Rezoning Transportation Analysis

Petition Number: 2024-029

Date	Description
04-24-24	First Review (IW)
05-22-24	Second Review (IW)

SHEET NUMBER RZ1-0

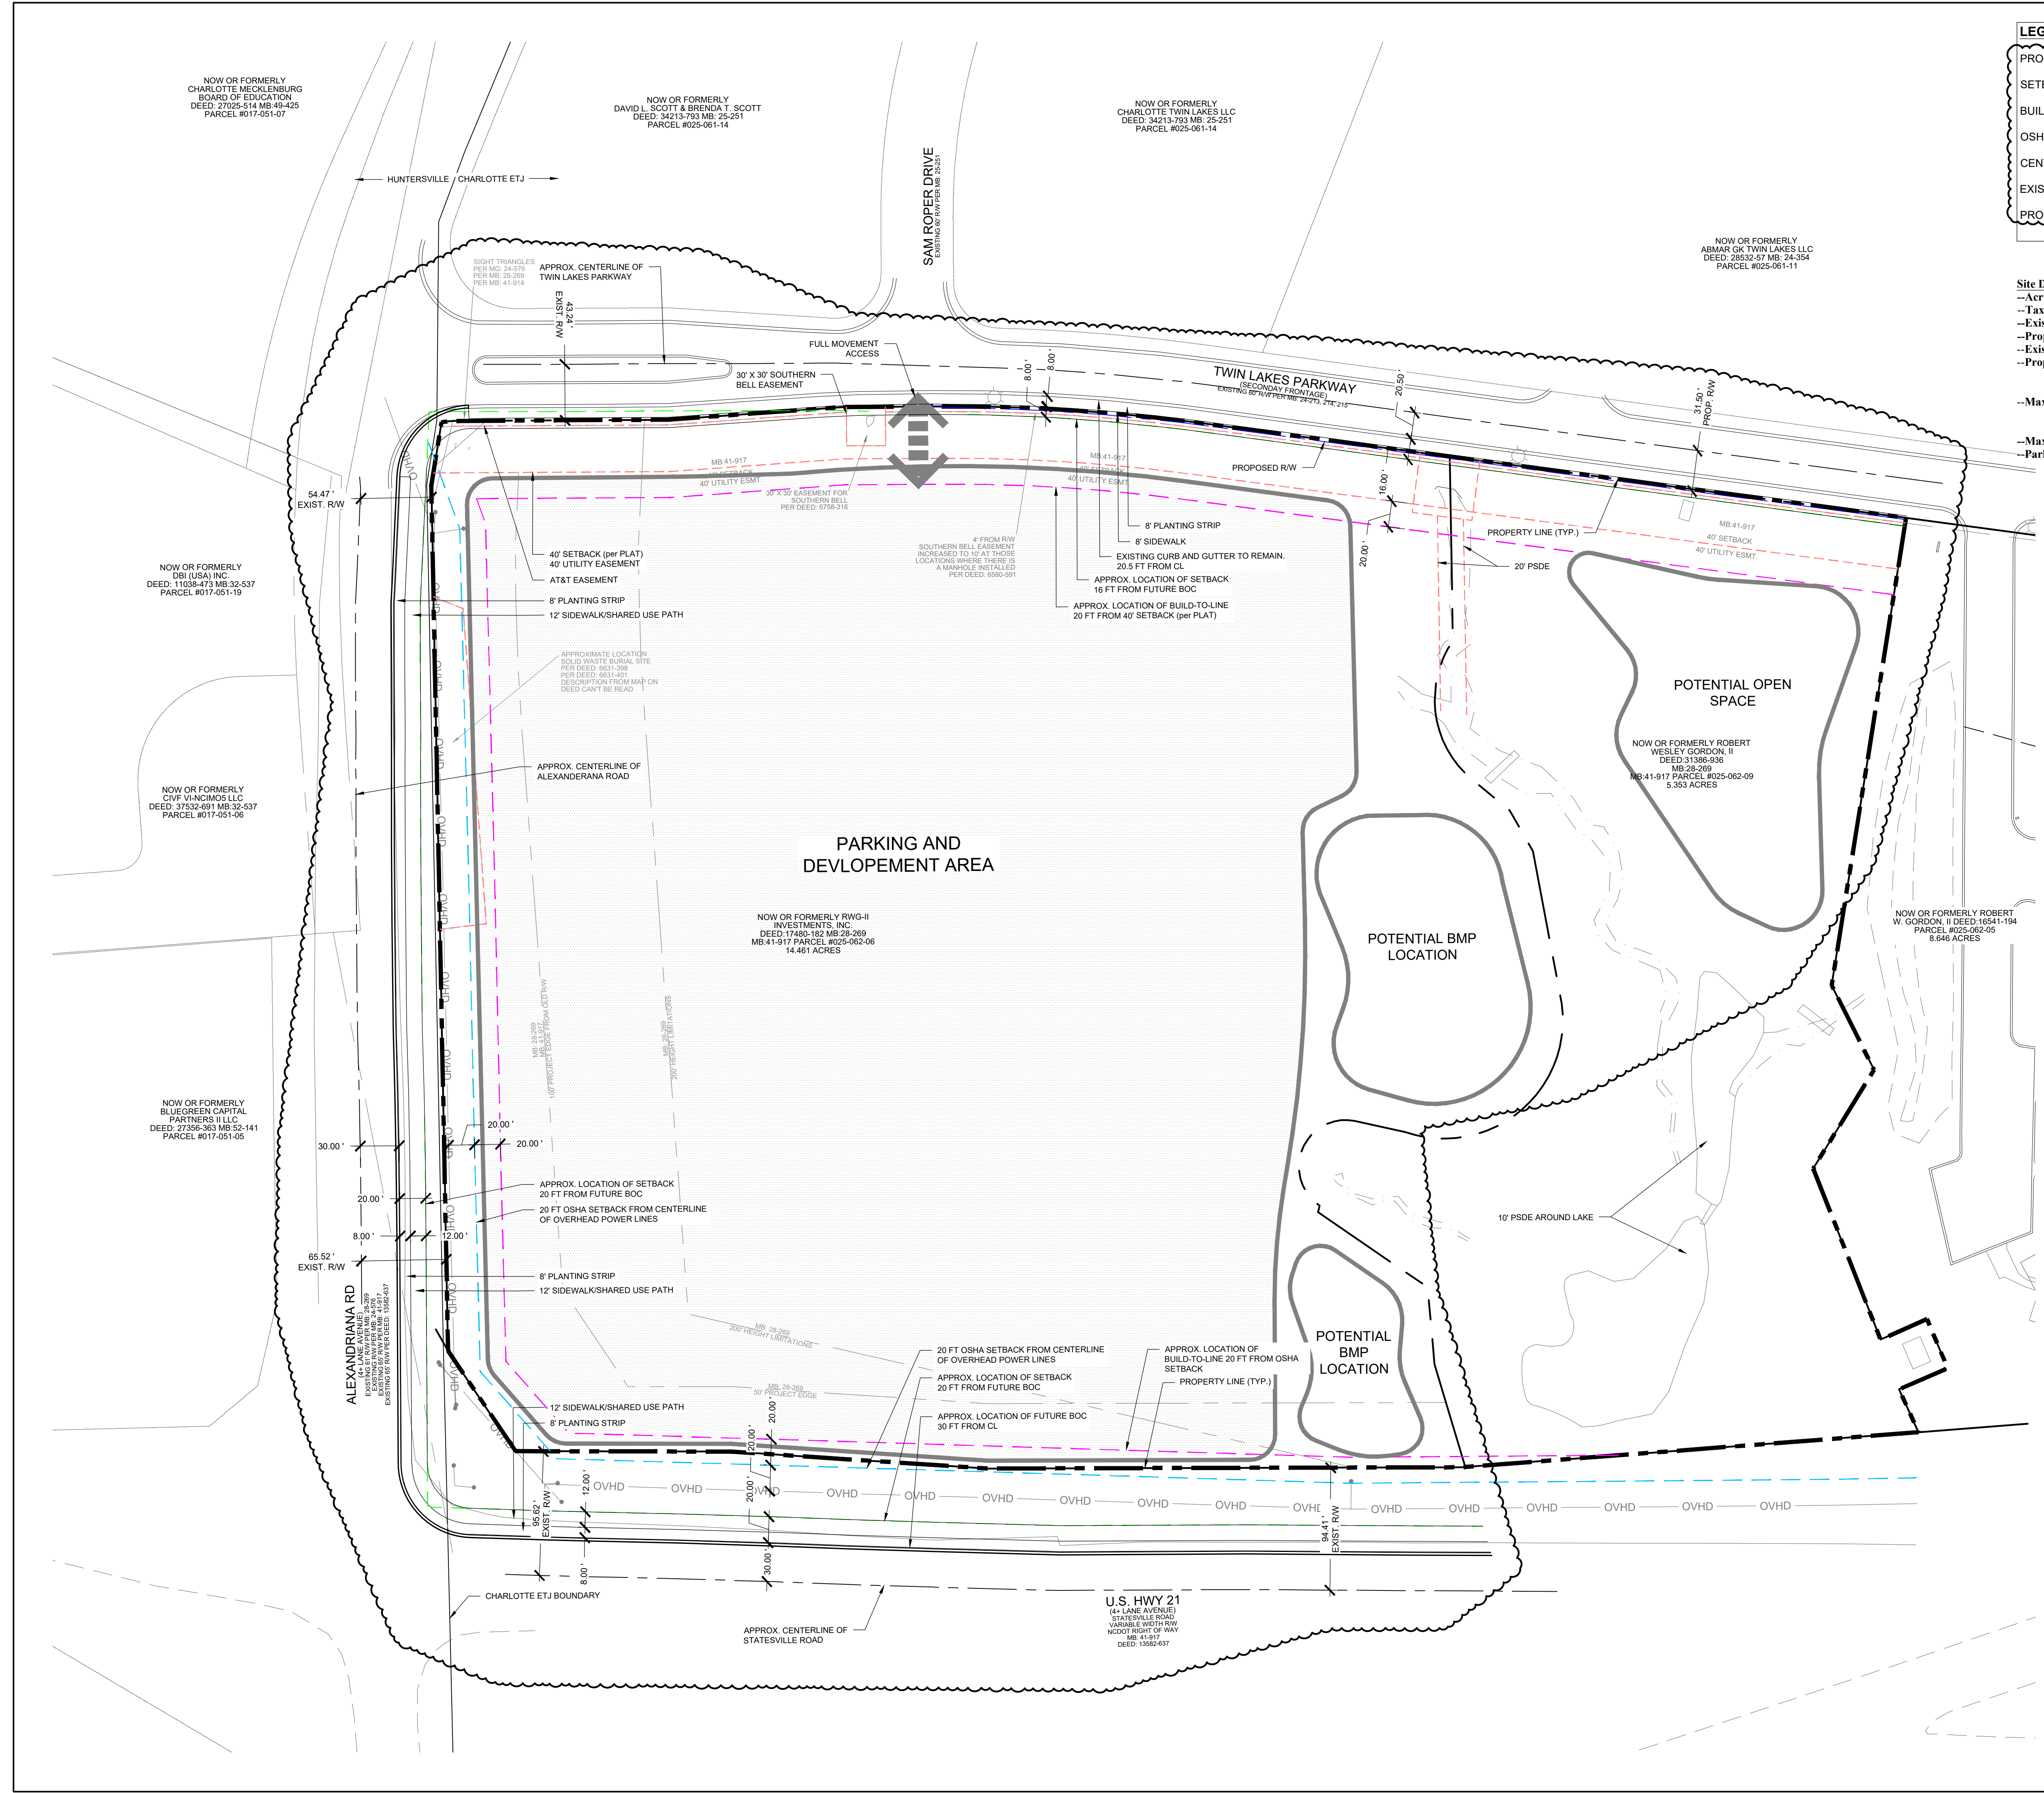
1. ~~Curblines:~~

- a. **Alexandriana Road:** Location of future back of curb and gutter to be constructed 30' from centerline.

- b. **Statesville Road:** Location of future back of curb and gutter to be constructed 30' from centerline.

- c. **Twin Lakes Pkwy:** Location of future back of curb and gutter to be 17.5' from centerline..

Label and dimension the curb and gutter from the centerline for each road on the site plan.

Clarifying Comment: Site plan shows dimensions but still needs to label the centerline to curb dimension along Alexandriana Rd as "Centerline to future curb location"
